ROADWAY AND STORM SEWER CONSTRUCTION PLANS  
FALCON MEADOWS AT BENT GRASS FILING NO. 3  
FALCON, CO 80831 - EL PASO COUNTY  
CHALLENGER COMMUNITIES, LLC

FUDSP-20-005 (FALCON MEADOWS AT BENT GRASS PRELIMINARY PLAN)  
SF-22-16 (FALCON MEADOWS AT BENT GRASS FILING NO. 3)

# Construction Drawings\_v2 redlines.pdf Markup Summary 7-25-2022

HENZLEE PLACE (STREET C)
STA: 7+00 - 9+43.65 SCALE: H: 1"=30' V: 1"=3'

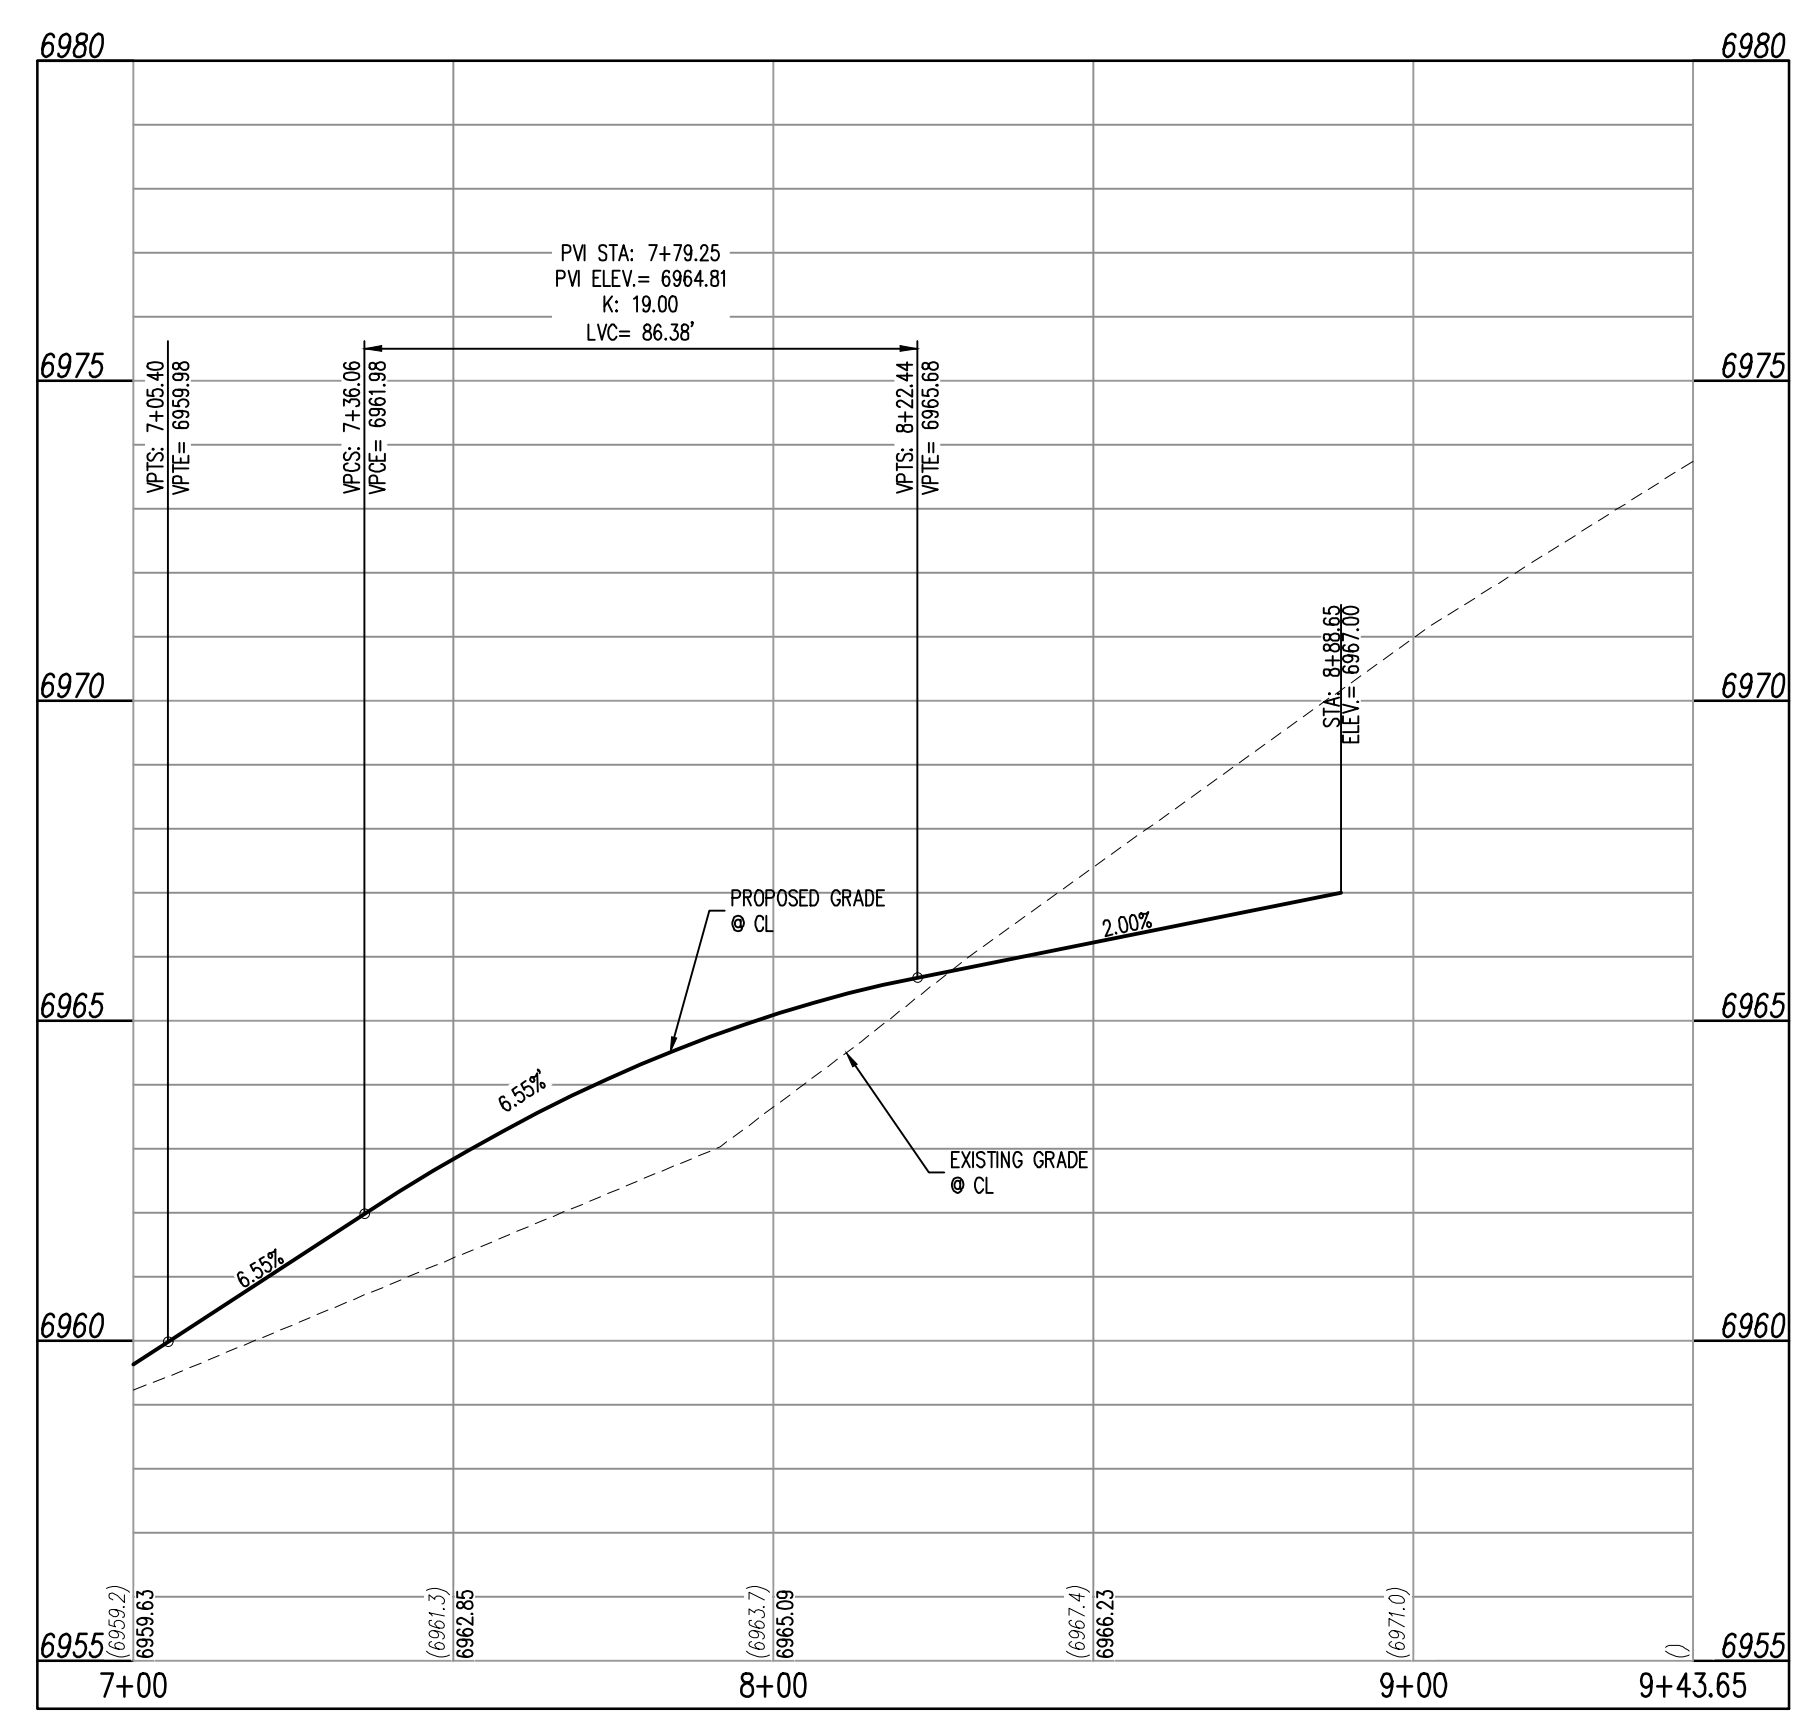
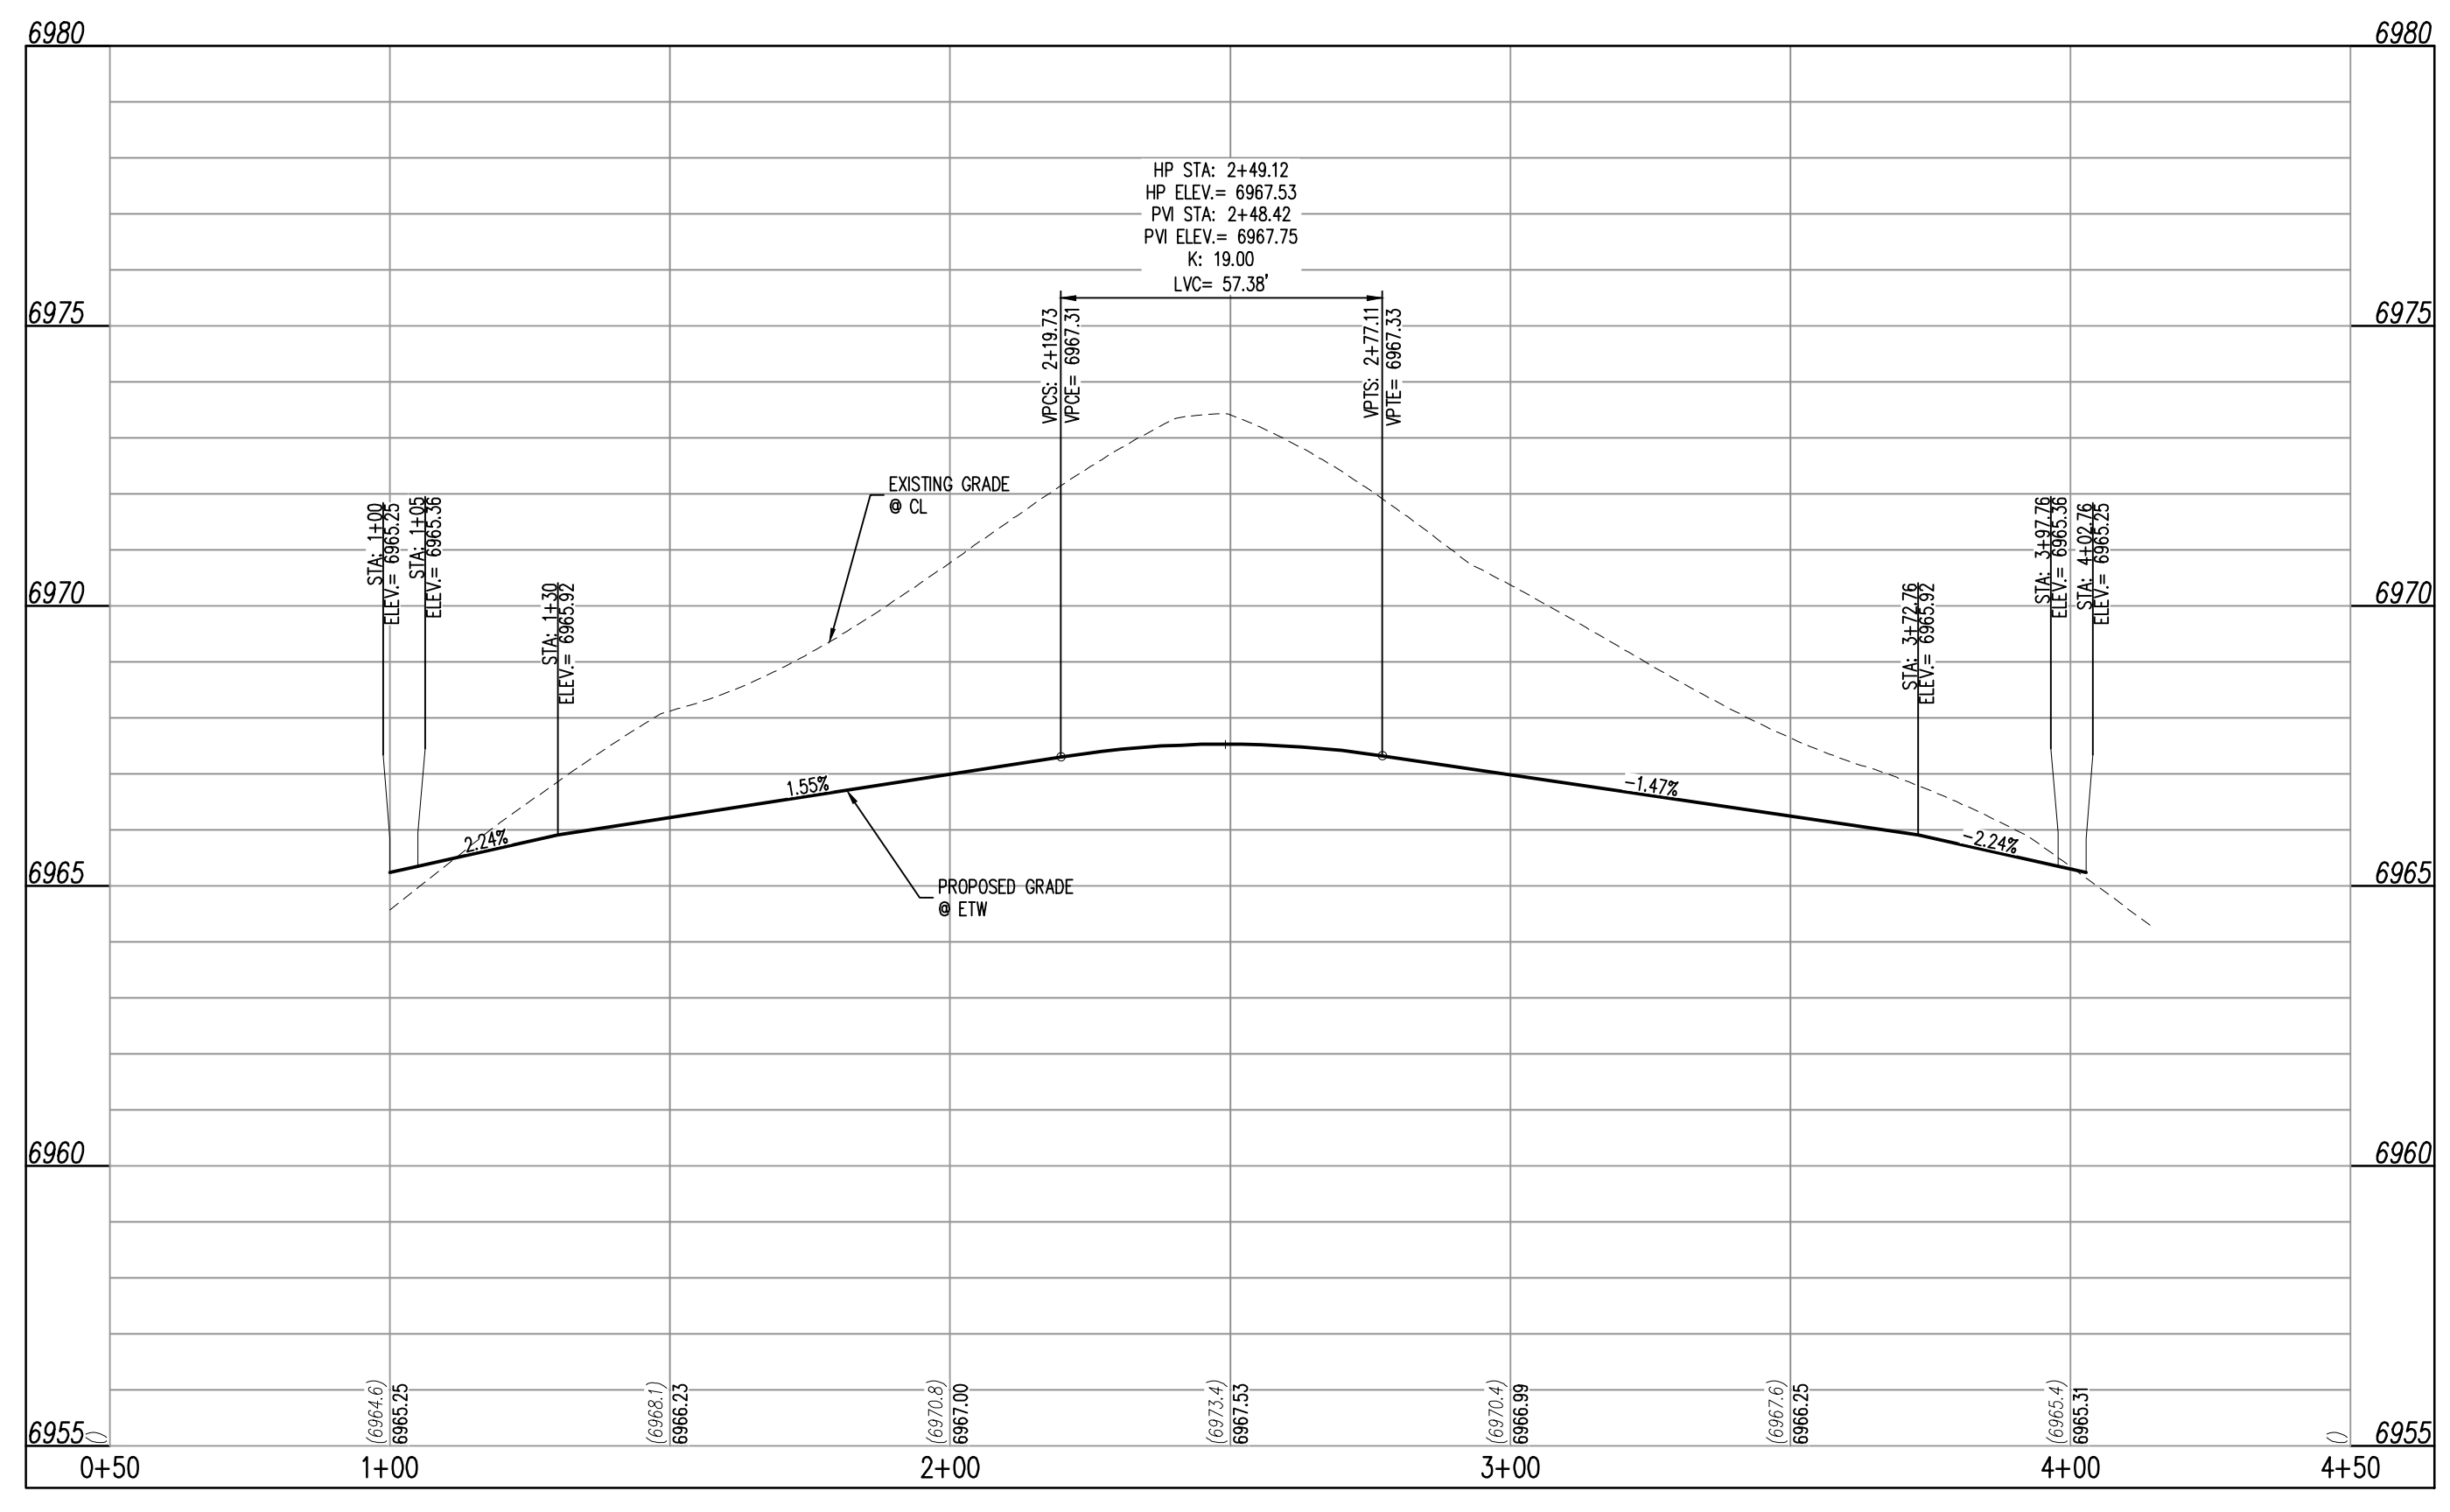
Please extend the profile to include the entirety of the vertical curve.
